**RE: Wilshire Place Subdivision
Conceptual Grading and Drainage Plan
Engineer's Stamp Date: 08/10/18
Hydrology File: C18D103**

Based upon the information provided in your resubmittal received 08/14/2018, the Conceptual Grading and Drainage Plan is approved for Preliminary Plat and Site Plan for Building Permit. This letter replaces the letter written on 8/17/2018.

Sheet Title
**DRAINAGE AND
CONCEPTUAL GRADING PLAN**
Date
AUGUST 10, 2018
Project No.

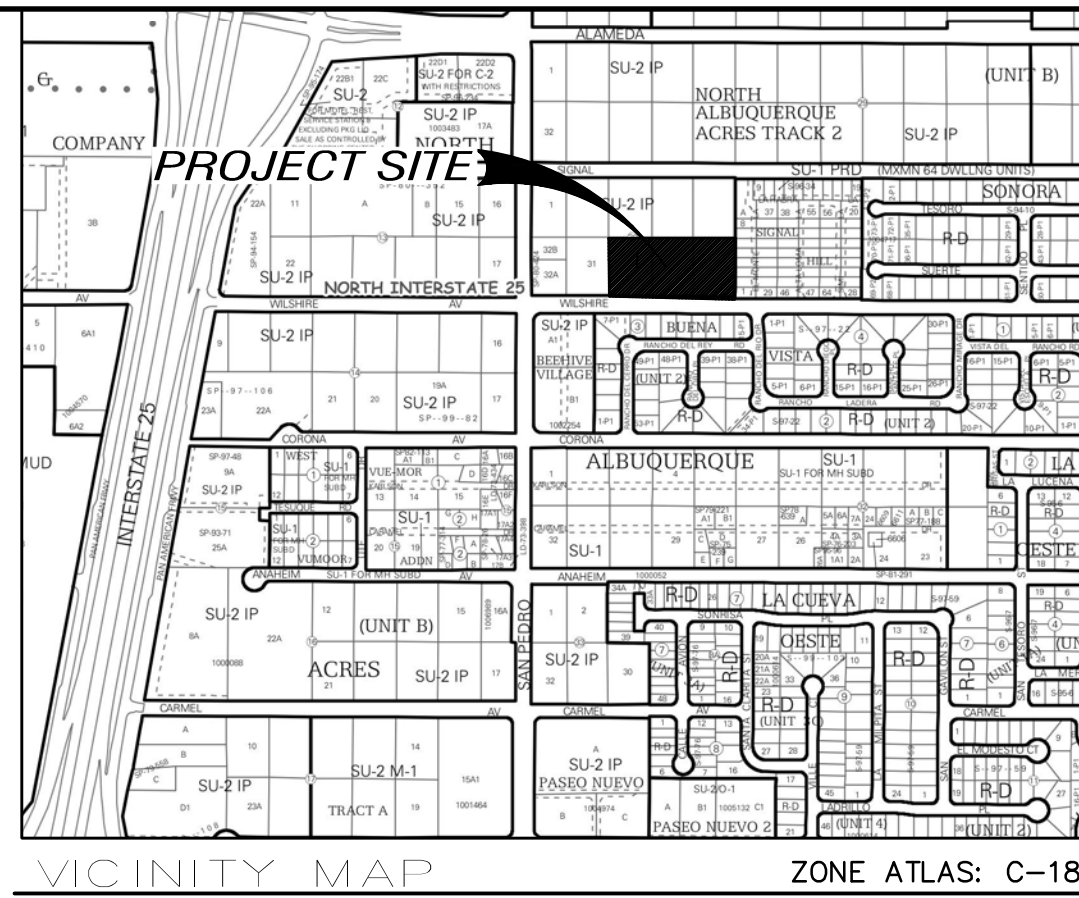
1. Clearly identify all retaining walls on the G&D Plan with a symbol in the legend and on the plan view. Differentiate between walls required by the developer (>2') and walls to be differed to home builders (<2').
2. Show a typical lot grading detail or swales on the individual lots. Include typical sections through the swales at the front of the pads, including both with and without side yard retaining wall.
3. Resolve overlapping text particularly on the pad elevations.
4. Provide hydrology and hydraulic calculations for the detention pond.
5. Provide typical sections of the streets, flow depth calculations, and inlet capacity calculations.
6. Verify downstream capacity or provide a temporary onsite retention pond to remain until the downstream capacity is provided by a separate project.
